From: NWNorthPlanning [NWNorthPlanning@environment-agency.gov.uk]
Sent: 05 February 2013 14:25
To: Jane Tucker
Subject: RE: Consultation on planning application 3/2013/0040 1-2 Ladycroft Cottage, Holden
Attachments: 1-2 Ladycroft cottages.pdf; FRSA_LPA_v_3_1_Jan_13_Update[1].pdf

1-2 Ladycroft Cottages

Drawing no
JJB/Pr 01

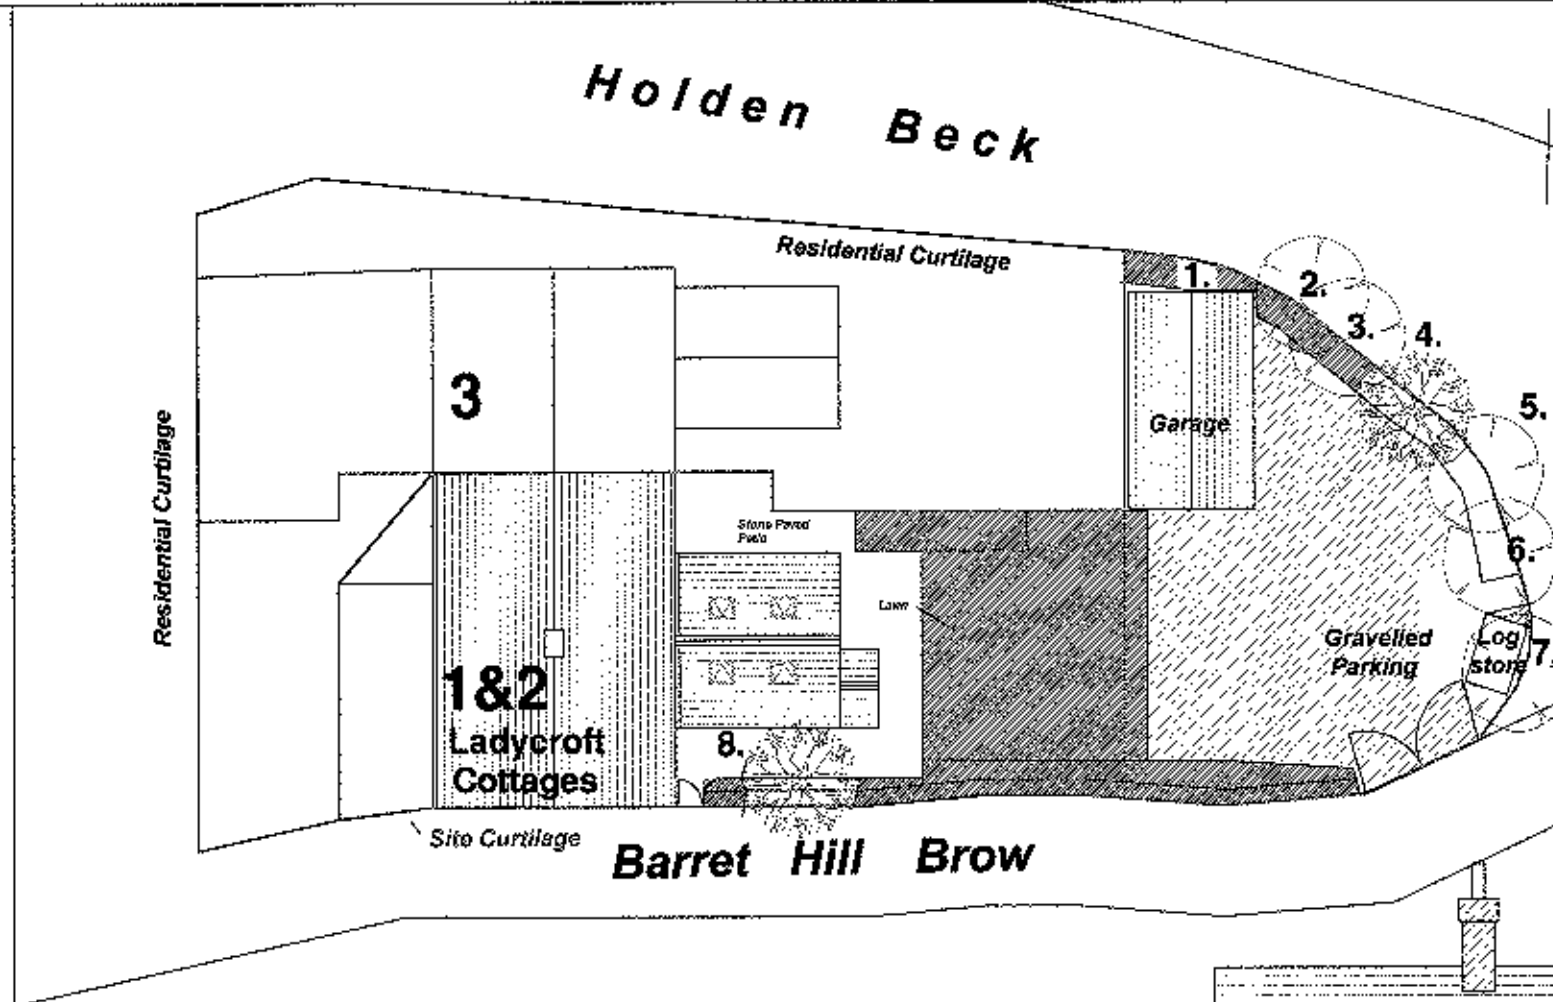
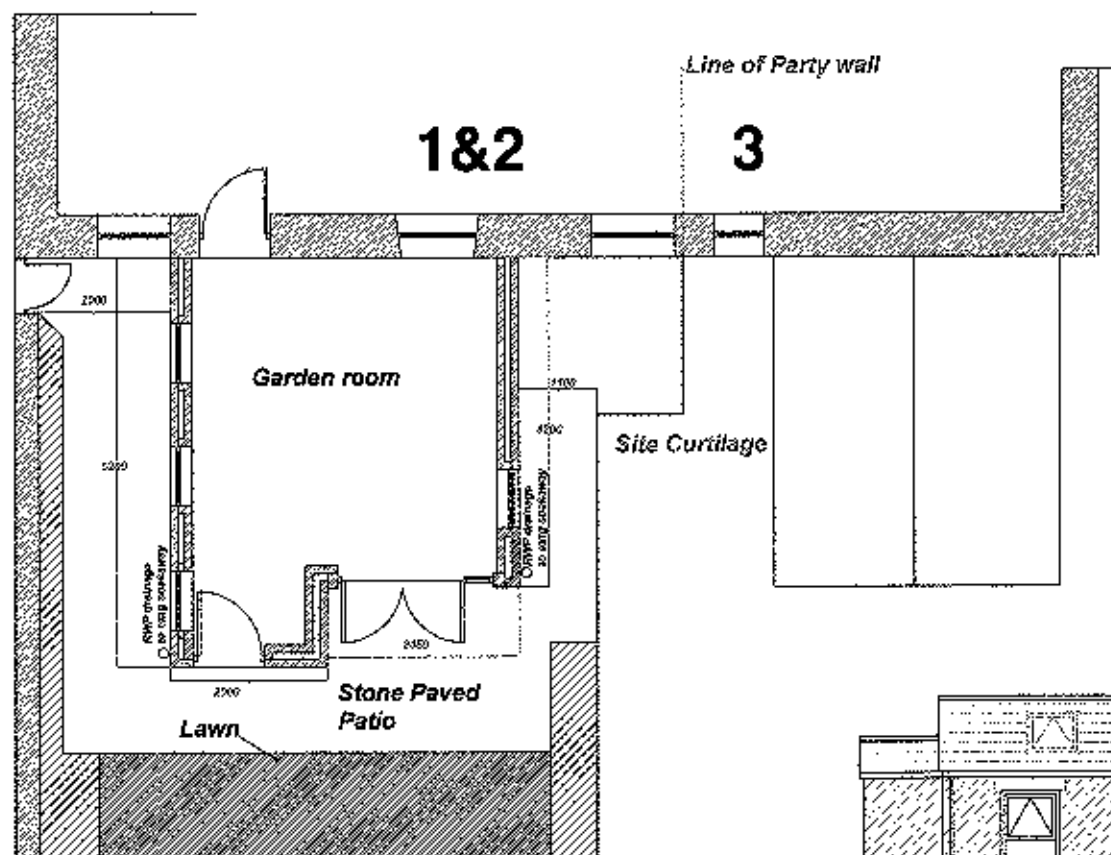
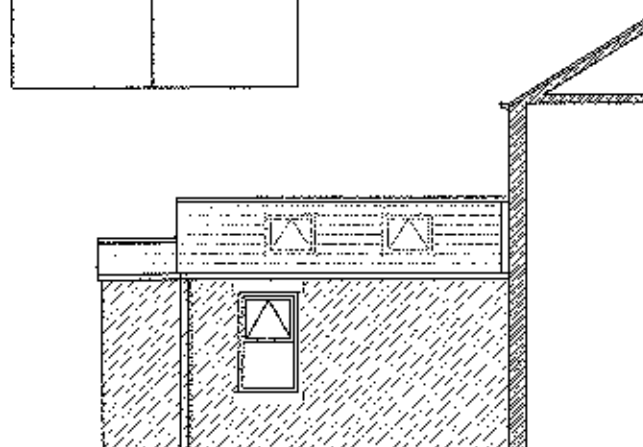
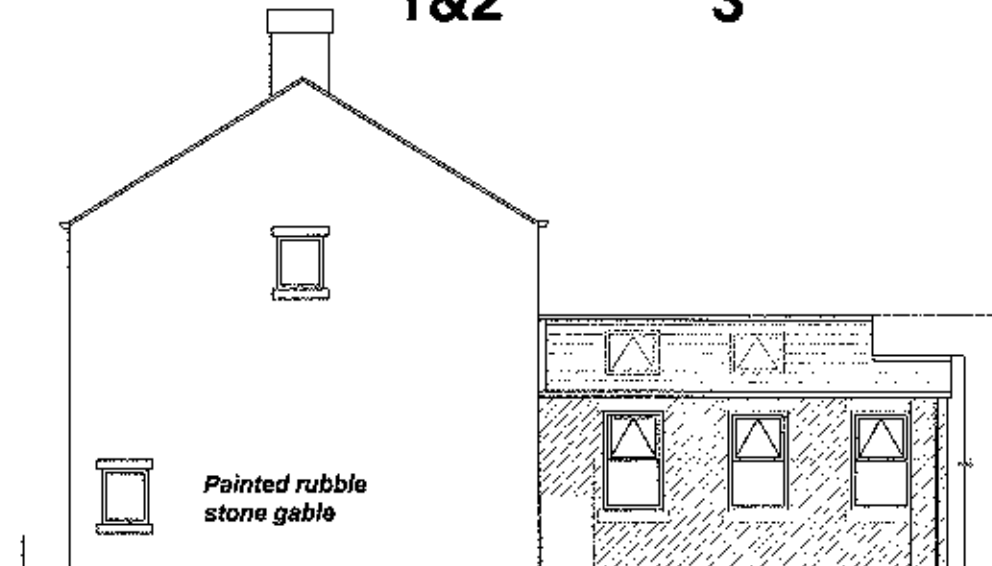
- a) The floor levels within the proposed development will be set no lower than existing levels AND flood proofing / resilience and resistance techniques, could be included in accordance with 'Improving the flood performance of new buildings' CLG (2007).

Alternatively, floor levels within the extension should be set 300mm above the known or modelled 1 in 100 annual probability river flood (1%) or 1 in 200 annual probability sea flood (0.5%) in any year. The levels should be relative to Ordnance Datum1

- b) Flood mitigation measures may be appropriate; this could include choosing appropriate floor materials, raising socket heights, using water resistant plaster.
- c) Attention is given to surface water drainage and disposal as not to increase the risk of flooding elsewhere, on or off the site.

Drawing no JJB/Pr 02 Rev

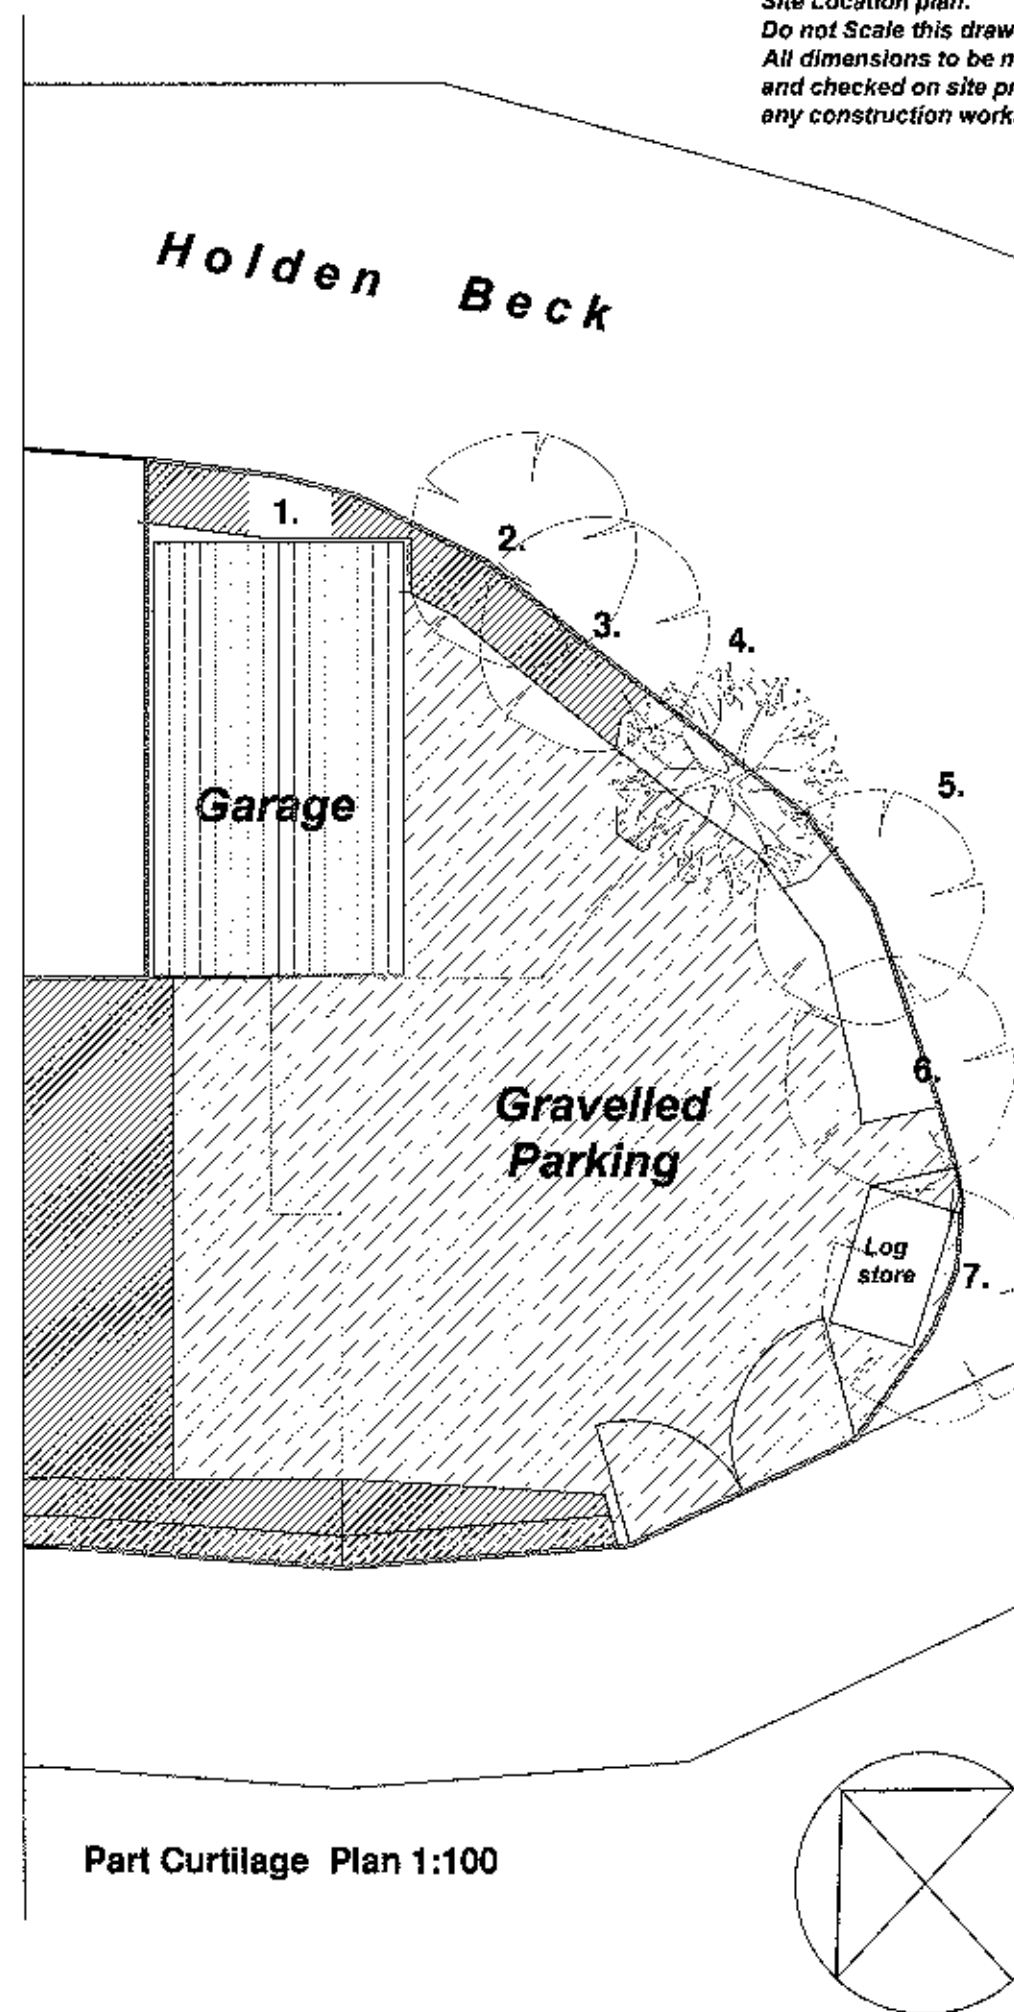
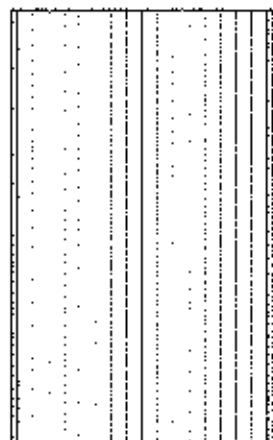
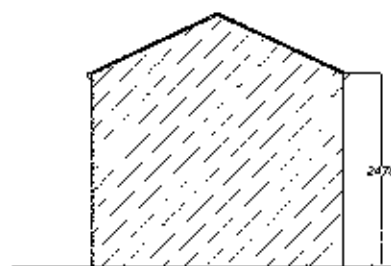
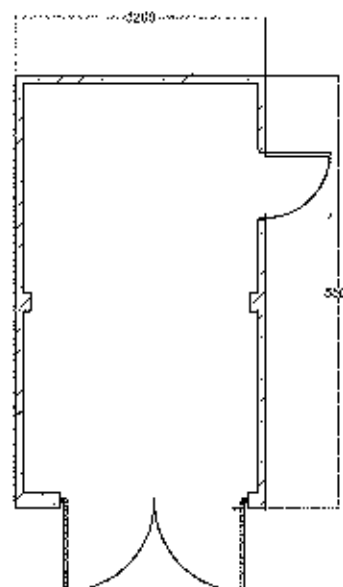
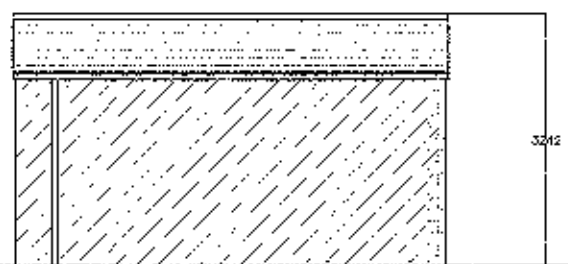
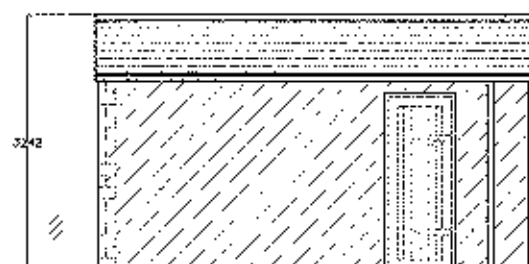
We would encourage you to consider a condition which ensures that the garage remains available for parking of domestic vehicles at all times so that it cannot be converted into residential accommodation ancillary to the main house (without express planning permission). Such steps could increase the risk of flooding to occupants.
